Your Ref: OWPC14840
Our Ref: BR/194/17/PL 30-06-2017
Please ask for:
Richard Temple

Demolition of the existing Foreshore office & decommissioning of existing underground toilets. New purpose built unisex toilet block including urinals, baby changing facilities & accessible WC, plus a separate beach office with public information point & first aid facilities. All located on the existing seafront promenade.

Promenade Opposite Clarence Road The Esplanade Bognor Regis

DRAWING
Proposed Toilet Elevations

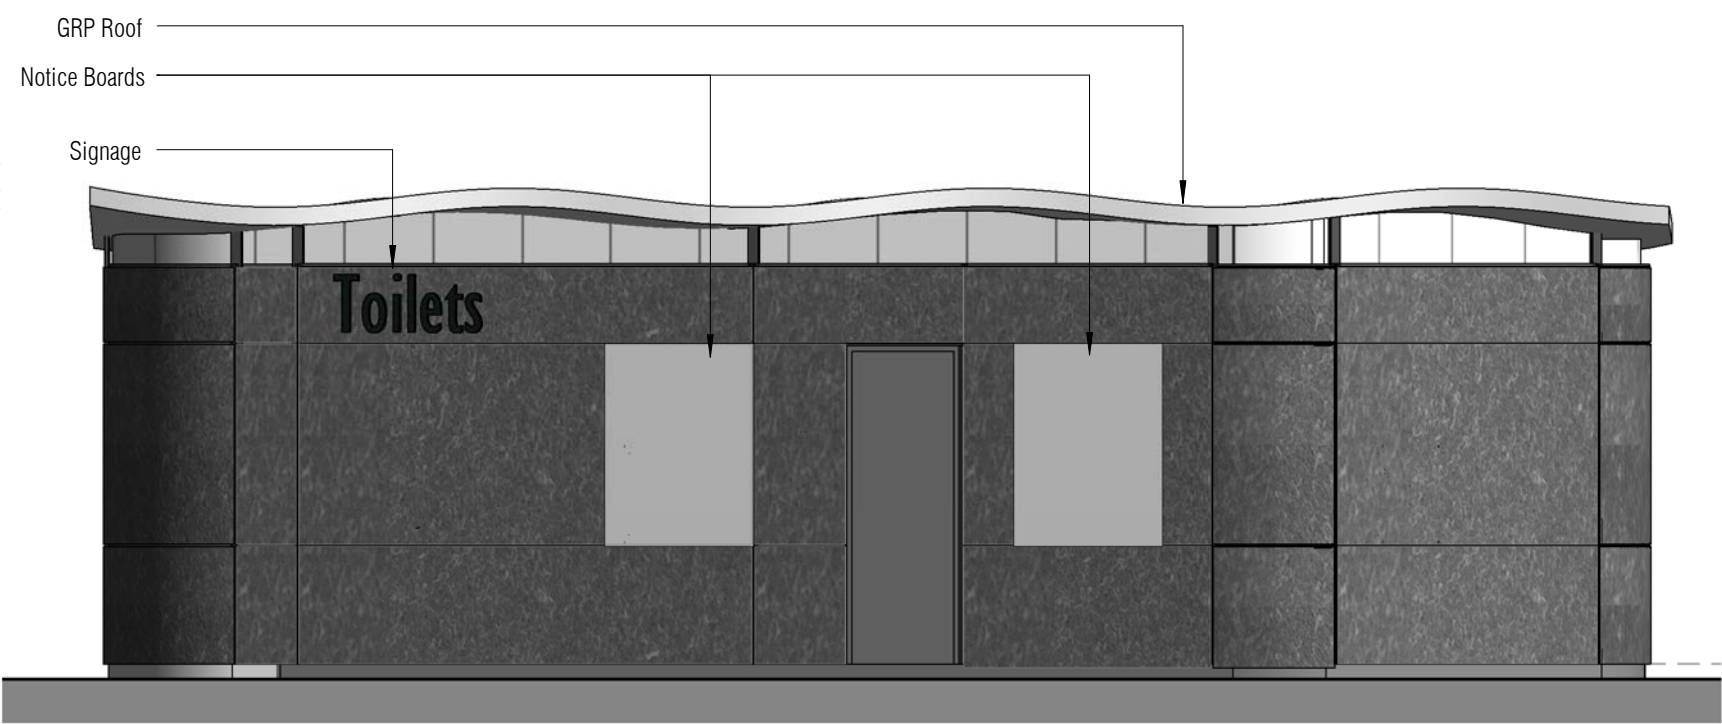
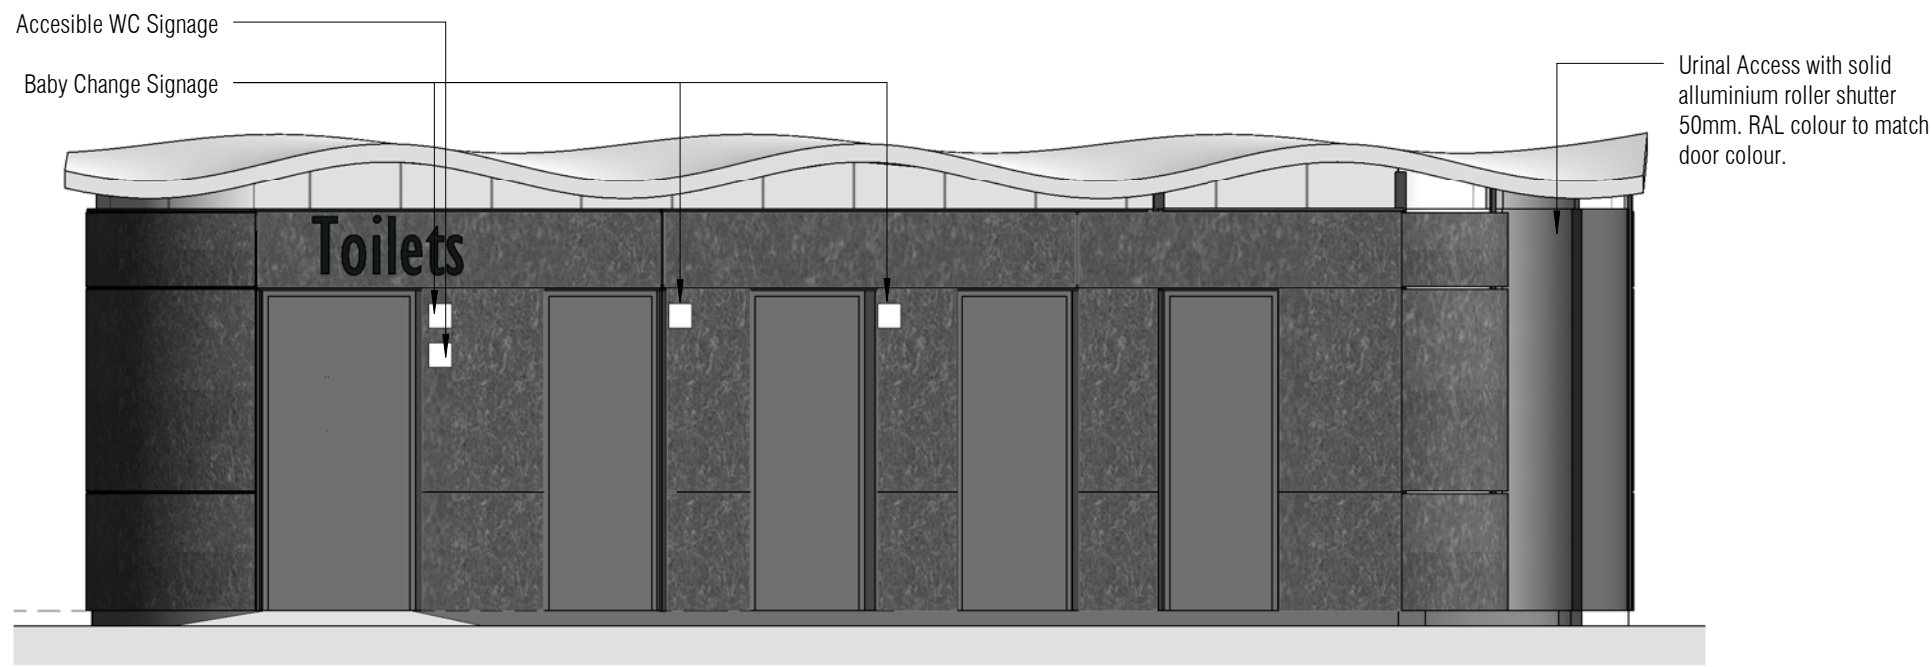
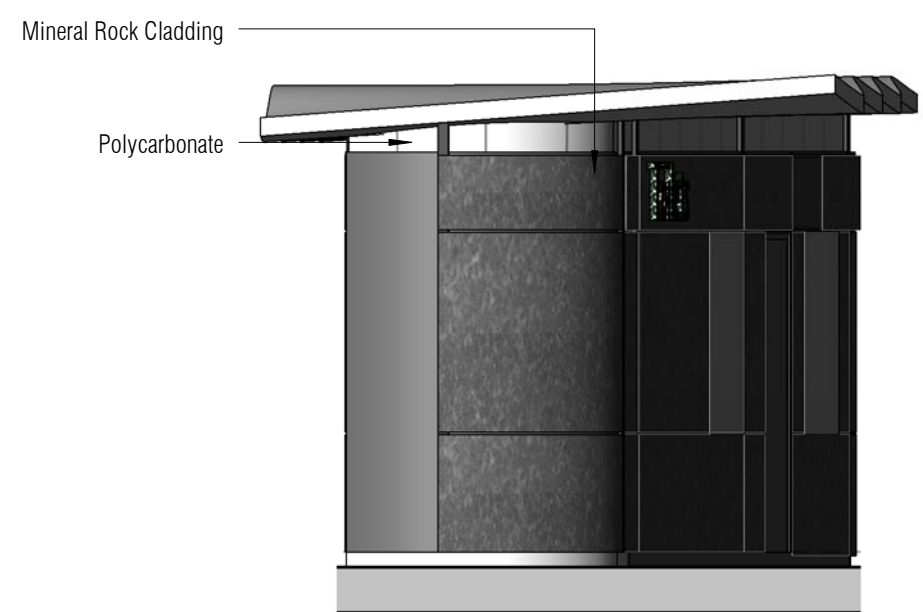
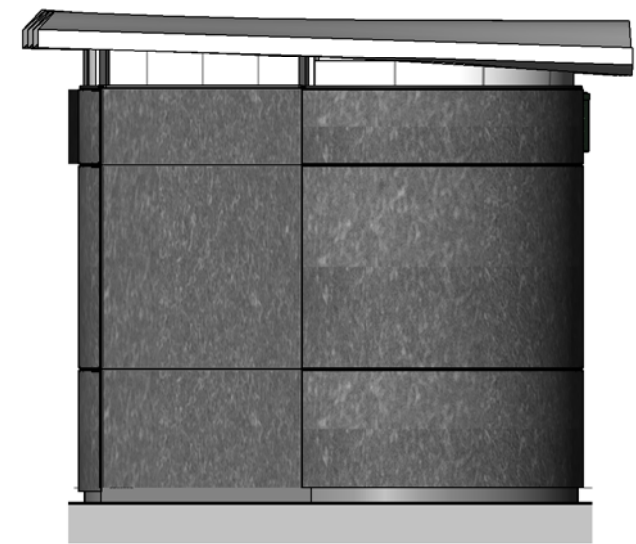
I Find it ridiculous that you could even consider have the toilet doors open to the roadside when everyone is looking towards the beach and out to sea apart from the residences across the street looking straight into the toilets. They should be located in the middle of the promenade where it is wider for the elderly and children to pass and closer to the town centre location.
